A1 Birtley to Coal House

Statement of Common Ground with Gateshead Council

STATEMENT OF COMMON GROUND WITH GATESHEAD COUNCIL

Regulation Number	Rule 8(1)(e)
Planning Inspectorate Scheme Reference	TR010031
Application Document Reference	TR010031/7.5A
Author:	A1 Birtley to Coal House Project Team, Highways England

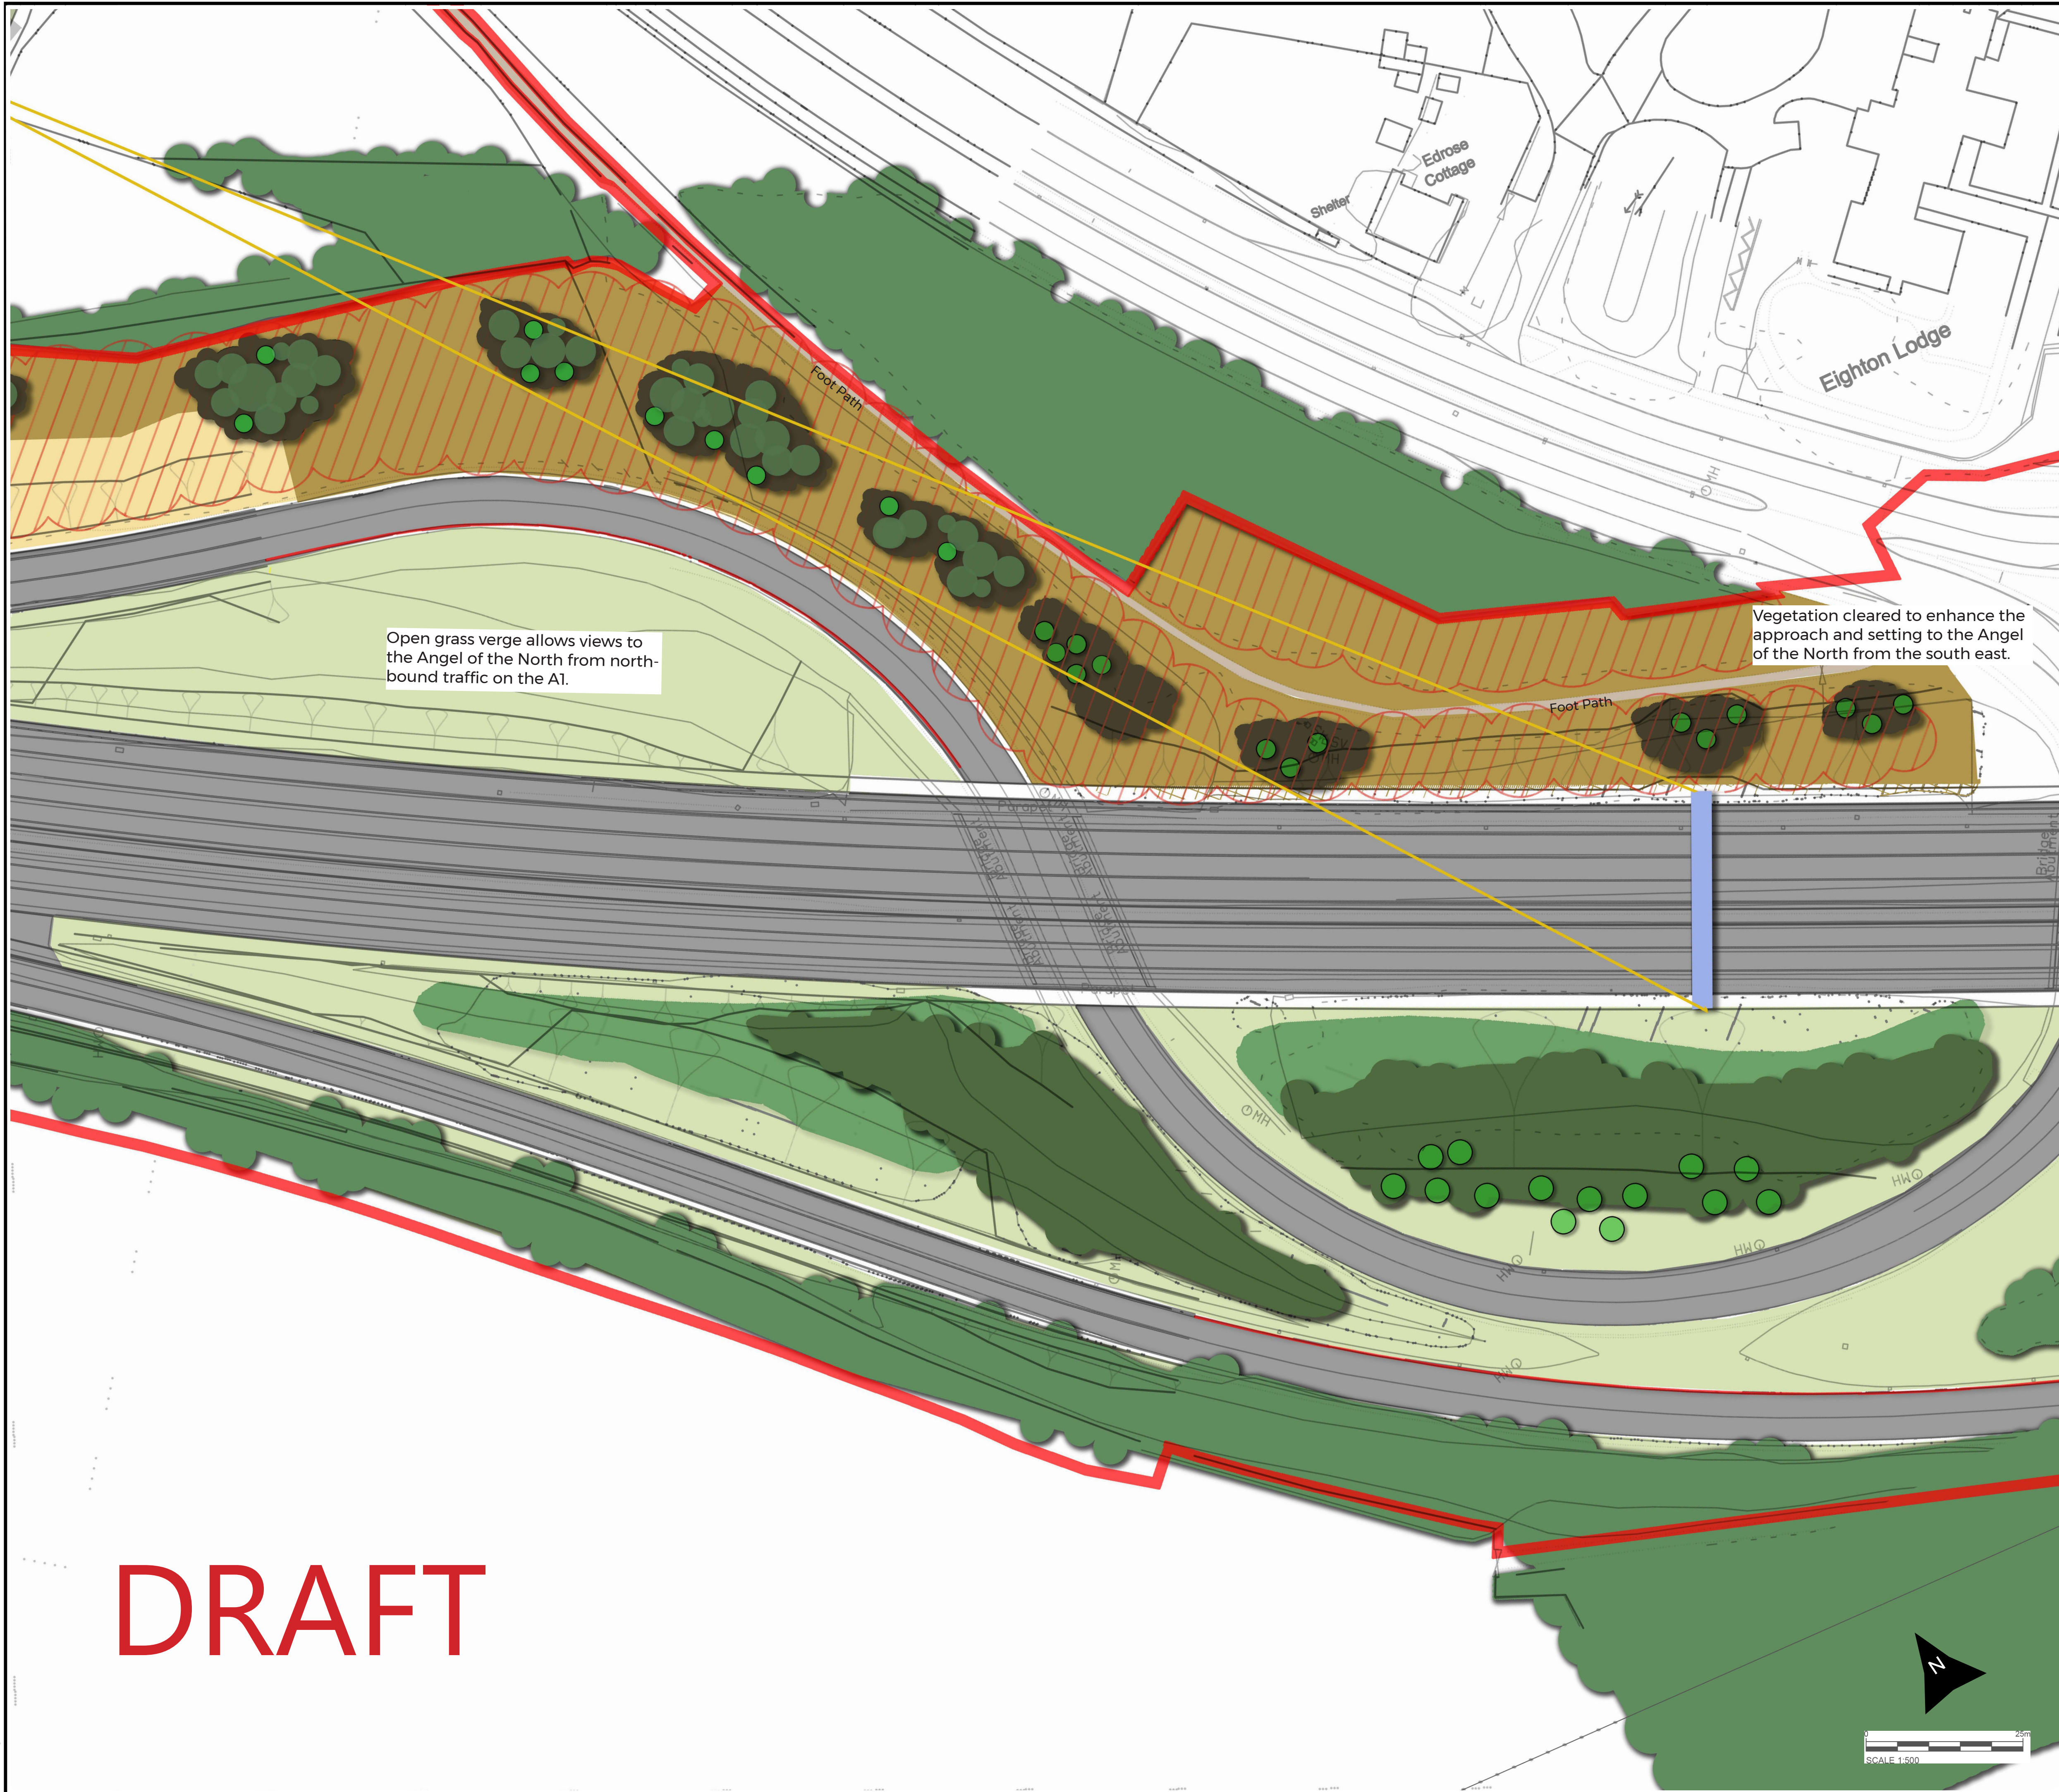
Section	Sub-section	Gateshead Council Position	Highways England Position	Status
Environmental Statement - Chapter 6: Cultural Heritage	6.8 Potential impacts	<p>In a meeting on 08/03/2018 on Gateshead Council's Conservation Officer asked Highways England to consider removal of trees along the A1 that currently obstruct the view of the Angel of the North. Removal of these trees is restricted for ecological reasons.</p> <p>Gateshead Council recognises tensions between artist, climate change and ecology views. Gateshead Council requested visuals of the proposed A1 works showing the landscape in its finished (post construction) massing would assist in developing the detailed landscape design and enable views to be managed alongside gantries and other infrastructure.</p> <p>The Council does not agree that there will permanent beneficial impacts on the setting of the Angel as a result of reduced planting, and the effect of the gantries will be significant.</p>	<p>Landscape Planting: There will be permanent beneficial impacts on the setting of the Angel of the North as a result of reduced planting giving greater potential for views which would improve the experience of the asset. This beneficial effect has been identified in a joint Gateshead Council Historic England study.</p> <p>Views from the road towards the Angel of the North would be slightly more restricted due to the installation of gantries but the effect would not be significant.</p> <p>Workshop to be arranged to discuss landscape and historic environmental issues affecting the setting of the Angel of the North.</p>	Under Discussion

Section	Sub-section	Gateshead Council Position	Highways England Position	Status
Chapter 7: Landscape and Visual	7.8 Potential impacts	<p>Under discussion, seeking additional details on landscape design to mitigate for the overhead signage.</p> <p>To be discussed at workshop – flythrough showed impacts on views of Angel of North from highway. Gateshead Council requested further discussions to ensure this impact is minimised.</p> <p>The Council states that that there is a material and negative impact on the Angel resulting from the scale of the new footbridge and the number and position of the proposed gantries. This impact can be offset by the implementation of the ‘Revealing the Angel’ scheme in the ‘Options Appraisal for Managing and Enhancing the Angel’ report, on both Council and Highways England land, with offsetting of tree planting numbers on another site in the Borough, to be agreed with the Council.</p>	<p>Section 7.8 of Chapter 7: Landscape and Visual of the ES [APP-028] summarises the predicted construction and operation impacts of the Scheme.</p> <p>During construction, the Scheme the removal of roadside vegetation would, in places, expose views of the existing A1, associated construction activity and traffic management. The Landscape Mitigation Design, Figure 7.6 of the ES [APP-061] identifies where existing vegetation would be removed and where new planting would be created. The impact of vegetation removal would be minimised due to either the current shape of the land, retained vegetation within the adjacent landscape or existing buildings.</p> <p>During operation, the Scheme is operational there would be some changes to the character of the surrounding areas.</p>	Under discussion
